CITY OF ALBUQUERQUE

August 5, 2015

**Re: Dreamstyle Warehouse, 1525 Renaissance
Grading and Drainage Plan
Engineer's Stamp Date 7-21-2015 (F16-D051A)**

ENGINEER'S SEAL	TRACT 9A RENAISSANCE CENTER	DRAWN BY BJF
	GRADING AND DRAINAGE PLAN	DATE 7/20/15
RONALD B. BOHANNAN P.E. #7868	 TIERRA WEST, LLC 5571 MIDWAY PARK PLACE NE ALBUQUERQUE, NM 87109 (505) 858-3100 www.tierrawestllc.com	SHEET # D1
		JOB # 2015009

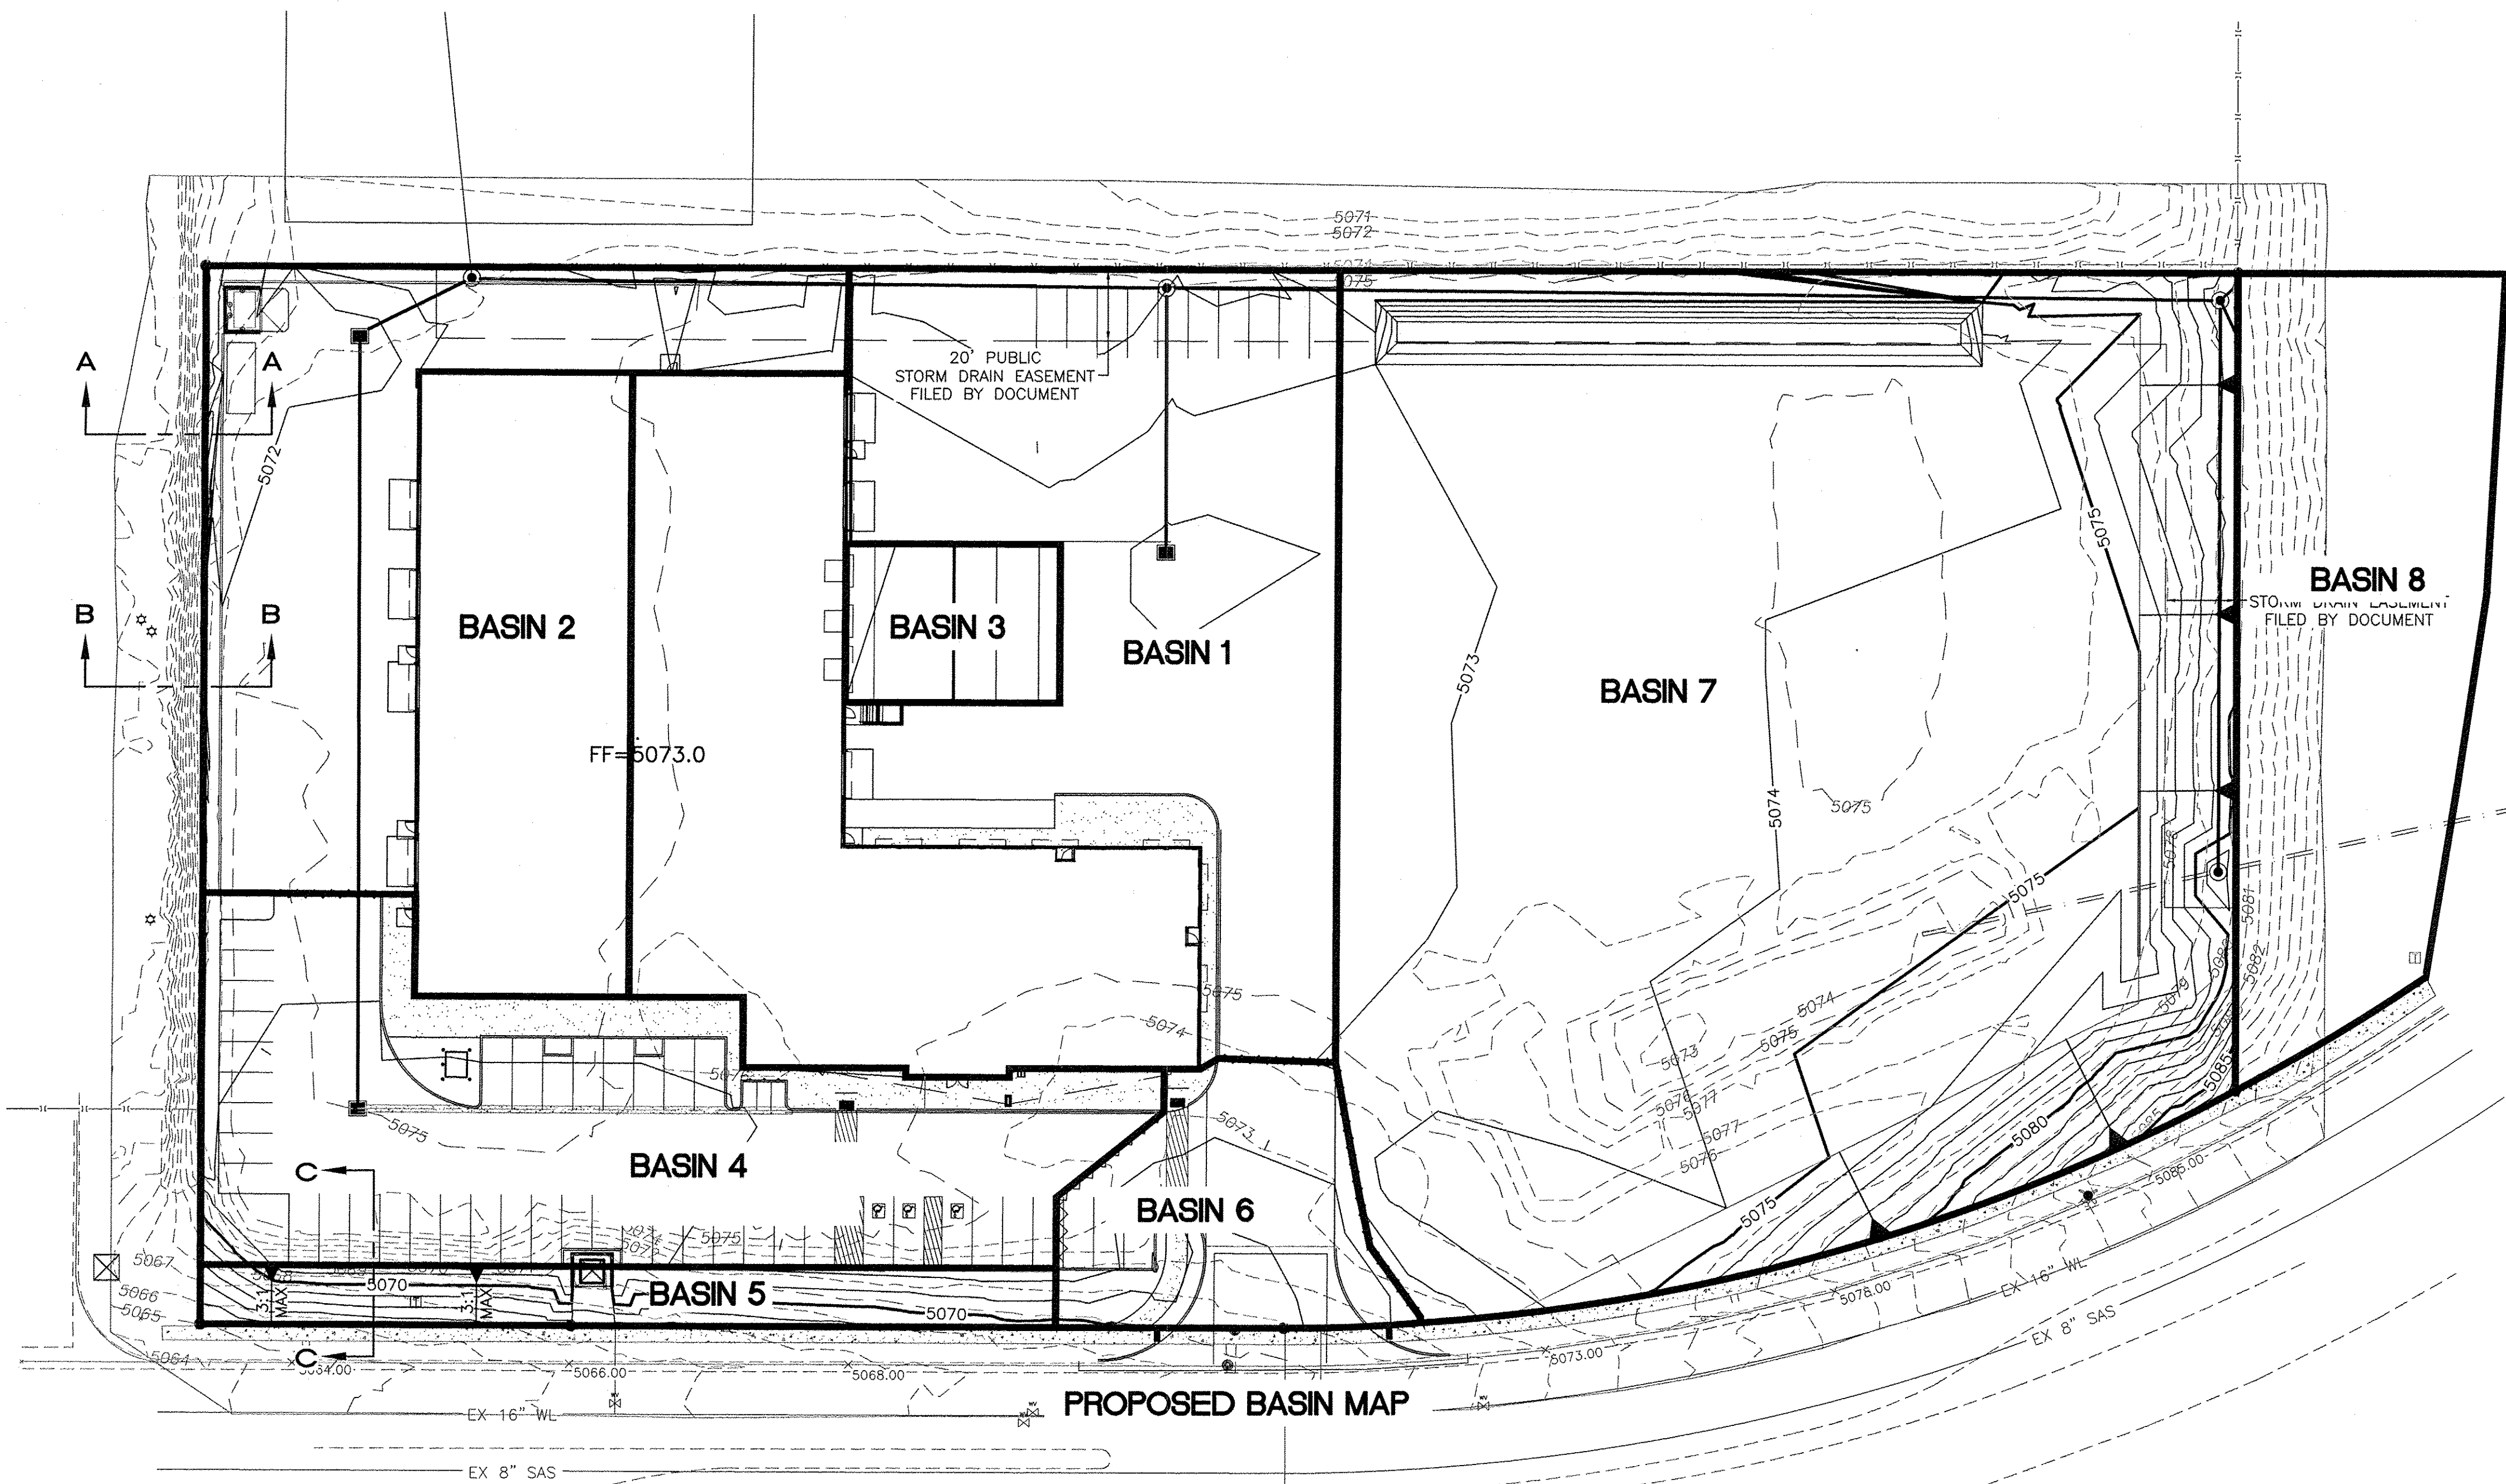
- A recorded "Drainage Easement" for the conveyance of offsite runoff via storm drain pipe across this site will be required prior to Certification of Occupancy.
